Subject: RE: Planning Consultation on: LU/124/21/PL

Please see comments below from Private Sector Housing concerning the change of use from a residential institution to an 11-bed HMO.

Registered: 26th May 2021
Site Address: 18-22 East Street Littlehampton BN17 6AW
Grid Reference: 503013 102253
Description of Works: Change of use from C2 Residential Institution to HMO (Sui Generis). This site may affect the setting of listed buildings & affects the character & appearance of the East Street, Littlehampton Conservation Area.

Proposed Ground Floor Plan
1:100 @ A1

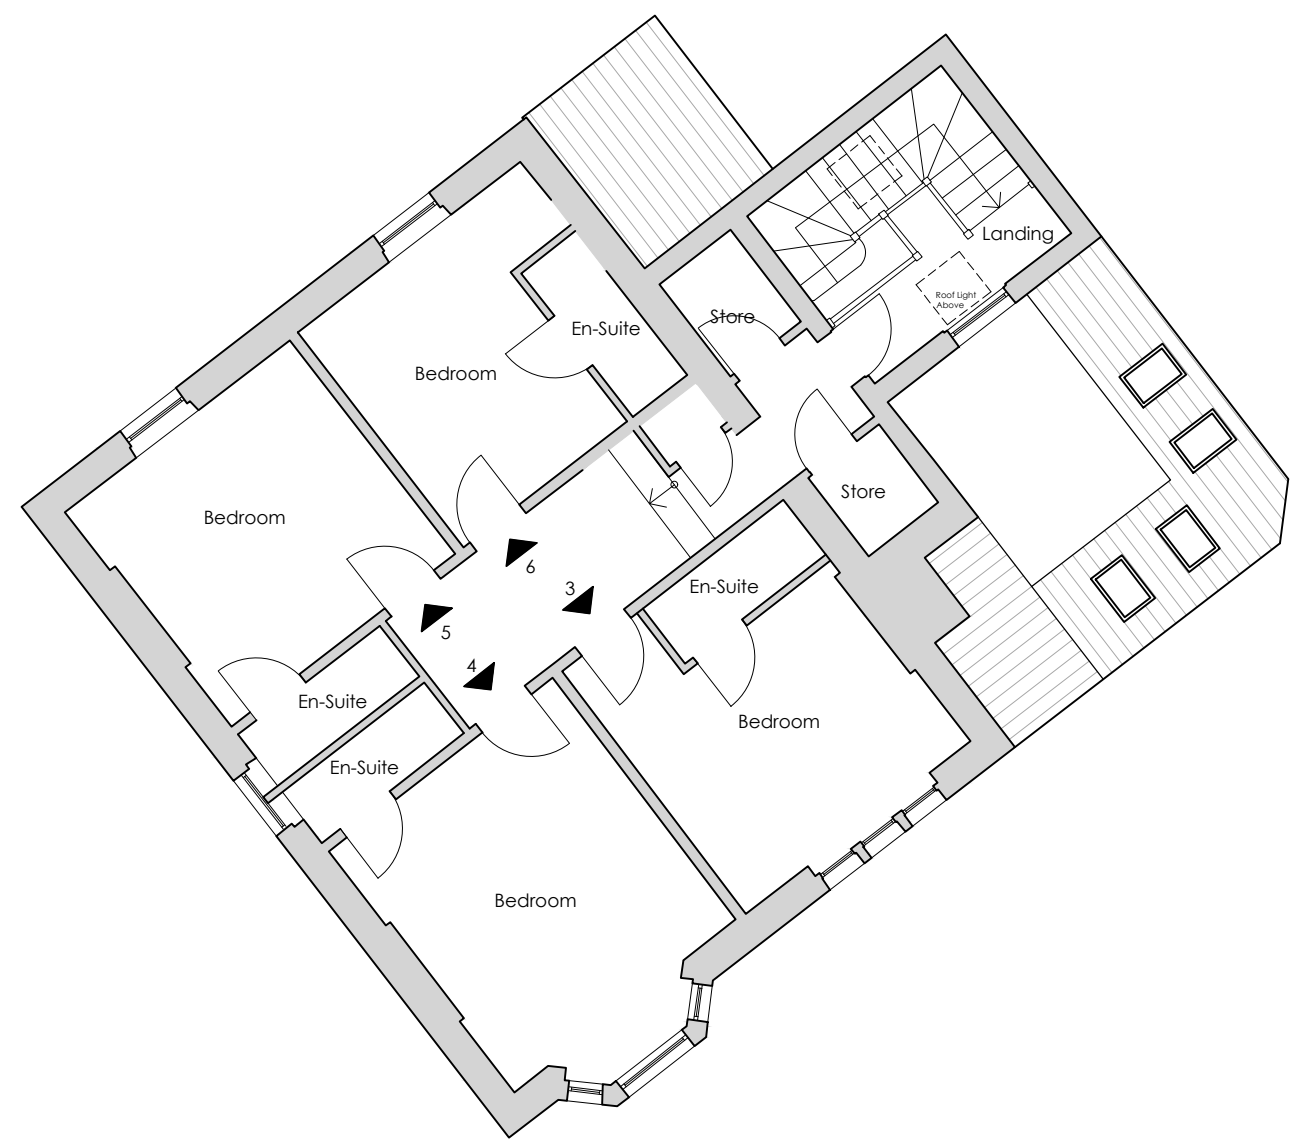
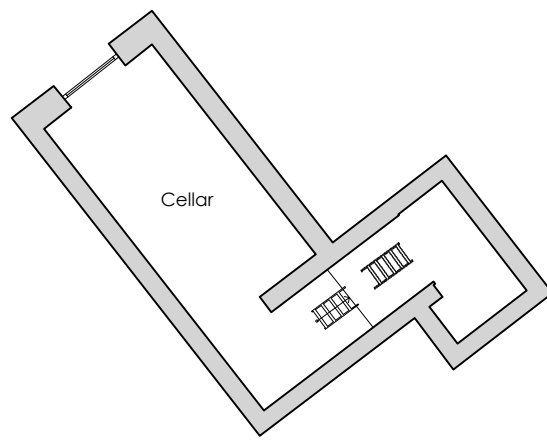
- Room sizes should meet the minimum standards for houses in multiple occupation. From a previous inspection of the property, it is noted that the ground floor rear bedroom within building 18-20 measured 6.32m²; this bedroom is suitable only for a child up to the age of 10 years. The minimum room sizes are as follows:
 - 4.64m² for a child under the age of 10
 - 6.51m² for single-occupancy
 - 10.2m² for double-occupancy
- N.B. The minimum room sizes above are dependant on the kitchen and communal room measurements – please refer to Arun's HMO Standards

Proposed First Floor Plan
1:100 @ A1

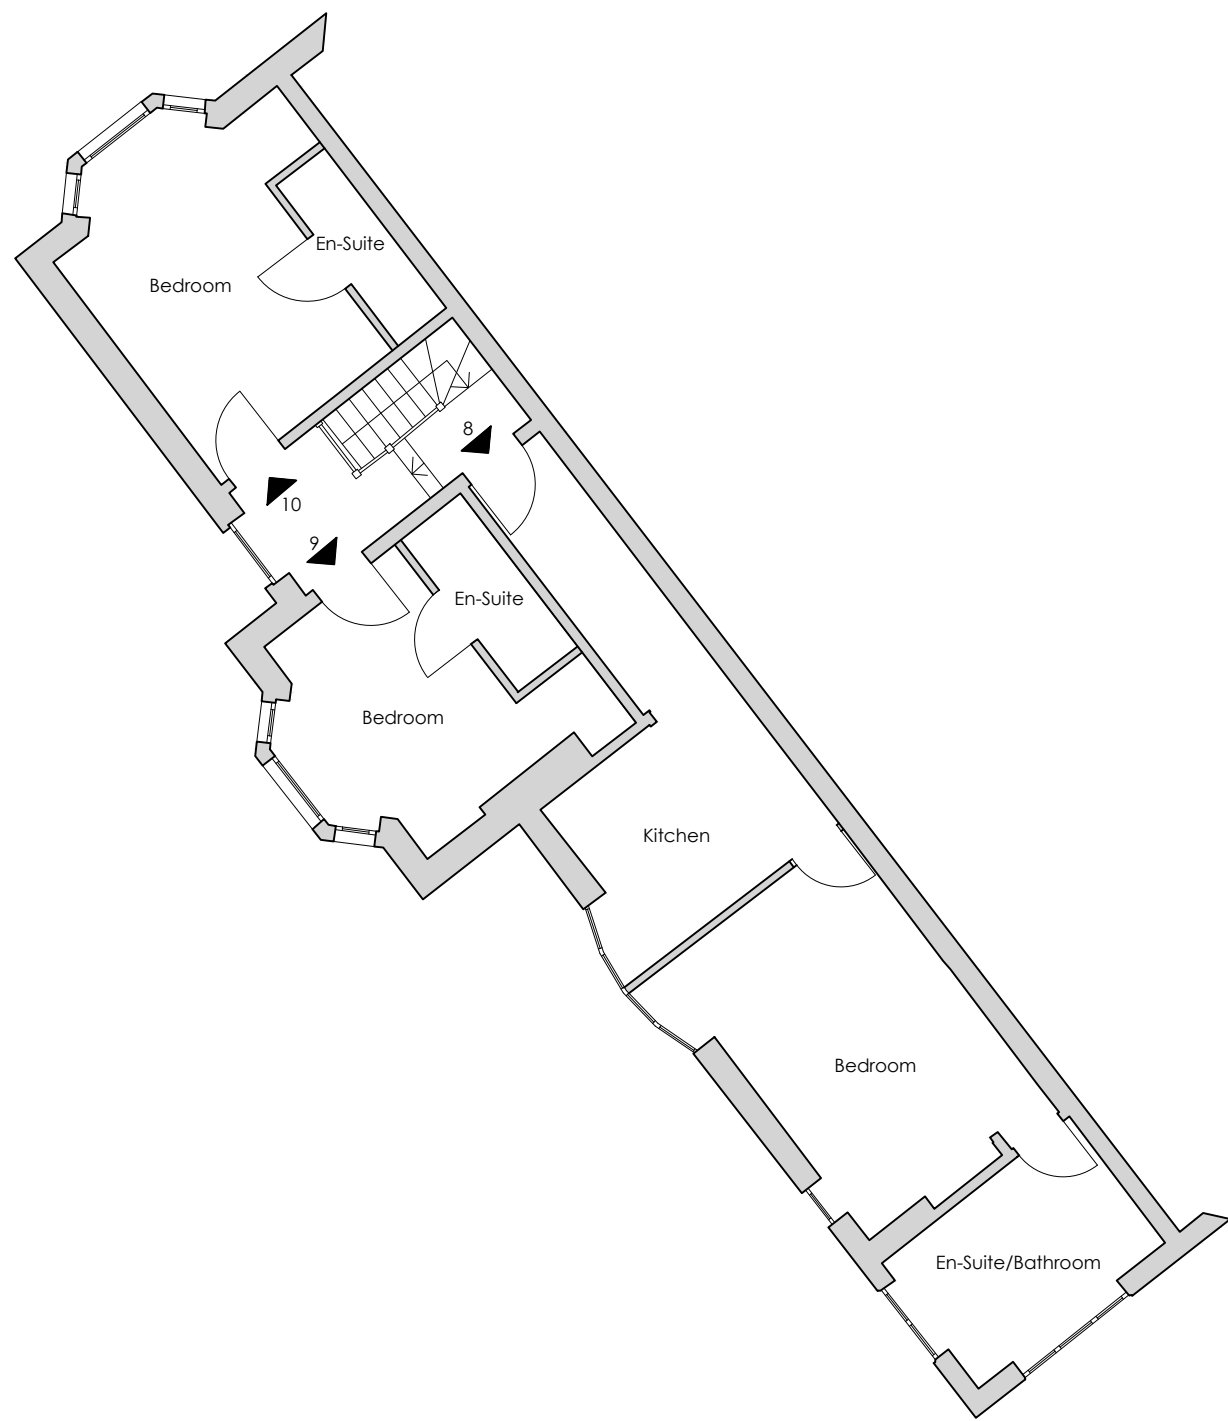
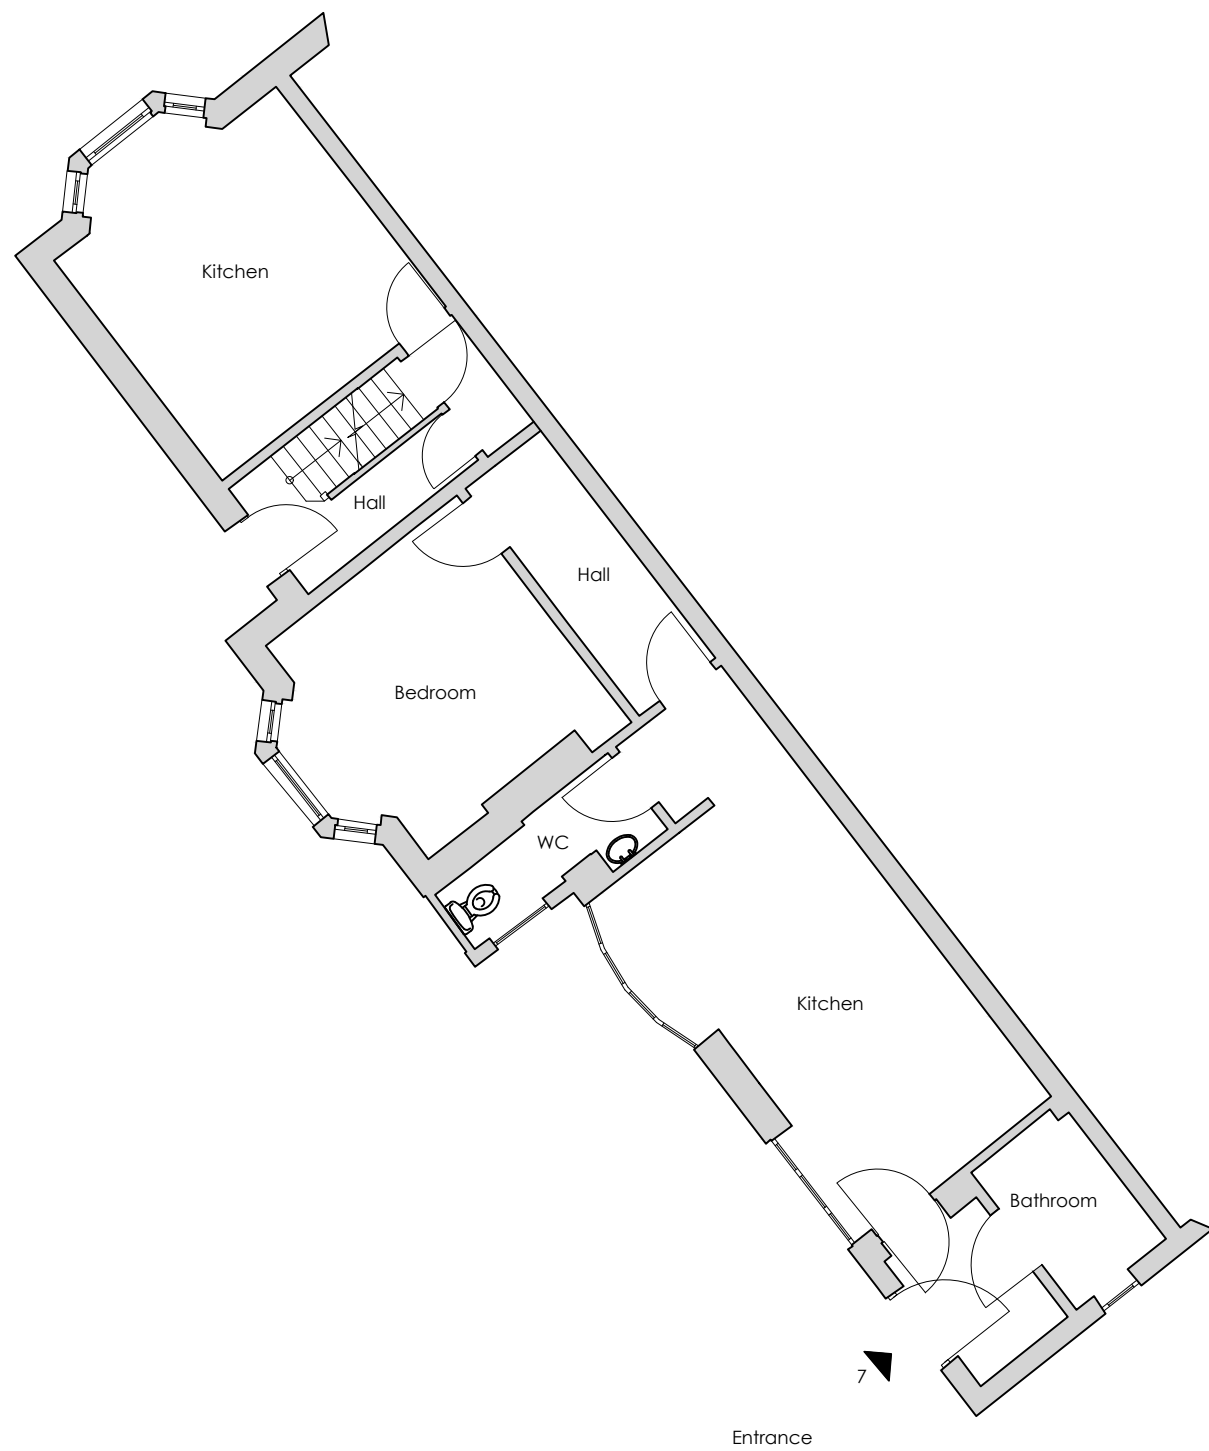
- No.22 – A room where the only escape route is through another room is termed an “inner room” and poses a risk to its occupiers if a fire starts unnoticed in the outer room. The first floor rear bedroom within building 22 is an inner room as egress is via the kitchen. An escape window should be installed to the bedroom, but only if all of the following criteria can be met:

- They serve rooms whose floor level is no more than 4.5m from the ground;
 - Every room served by the escape window has access to it without entering another habitable room;

- If it is necessary to pass through the escape route to reach the window, consideration should be had to the travel distance involved;
 - Occupiers are able-bodied individuals who can reasonably be expected to exit via the window unaided;

- There is no basement well or other encumbrance beneath the window such as railings or a conservatory;
 - The escape window is openable from the inside without the need for a key and the ground below is level and free of obstructions; and

- The window should lead to a place of ultimate safety. However, if this leads into a courtyard or back garden where there is no exit, it should be at least as deep as the building is high

- No.22 – Ensure there is adequate compartmentation between the first floor rear bedroom and the kitchen (minimum 30 minutes fire separation)
